Demolition of existing dwelling to be replaced by 3/4 storey detached town house.  
Amendment following FP/49/09/

Gull Point (formerly Sea Girt) Outram Road Felpham

Thank you for your internet representation made on 13th November 2011 which has been recorded as **an objection** with the comments as follows:

Third Floor

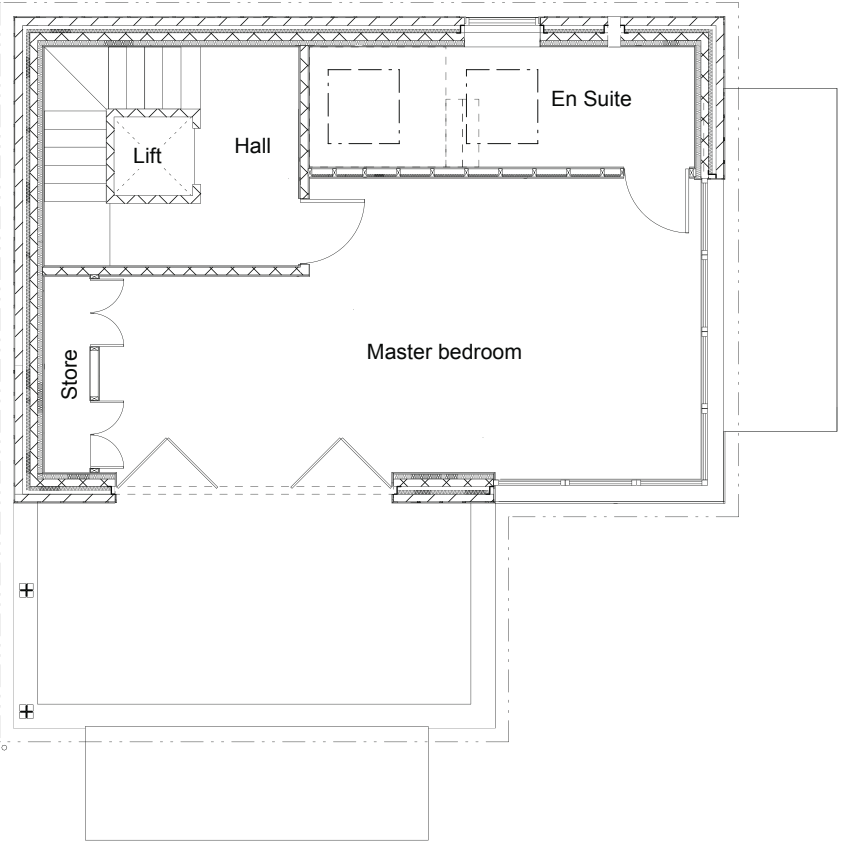
*The ammendments to the plans for Gull point are significant. The last plans show a top floor predominantly glass room, which is not to the edge of the plot/footprint. The imposing nature of the building was lessened by the stepping outline from the north and east elevations. I live in the property immediately north of the said site, and a solid wall and roof to the edge of the plot will have a significant effect on the light/shadow falling onto my property. This is of particular significance in the winter months due to the low level of the sun. I believe the ammendment to an already overpowering development of the site, is not in sympathy with the surrounding environment. I am therefore registering my objection to the ammendment and strongly feel that the previous permission should not be changed.*

*As the next door neighbour resident I would like to register my strong objection to the alteration of the original plans for Gull Point. The extension of the roof terrace to cover the full area of the third floor will have a detrimental impact on the amount of natural light which will fall on Sea Bank. Currently the house receives natural light to the front elevation until approx 1.30pm, with this change to the new build it is unlikely that we will get any sunlight on the house much beyond midday. □*

*The ammendments to the new design increases the top floor area, adding more to the eastern elevation, blocking more sunlight to Sea Banks garden area. The prior design had living space set back on the west side, with a platform to the east, the new design fills in this platform area with roofed living space adding extra height to the west end elevation, blocking sunlight to Sea bank.*
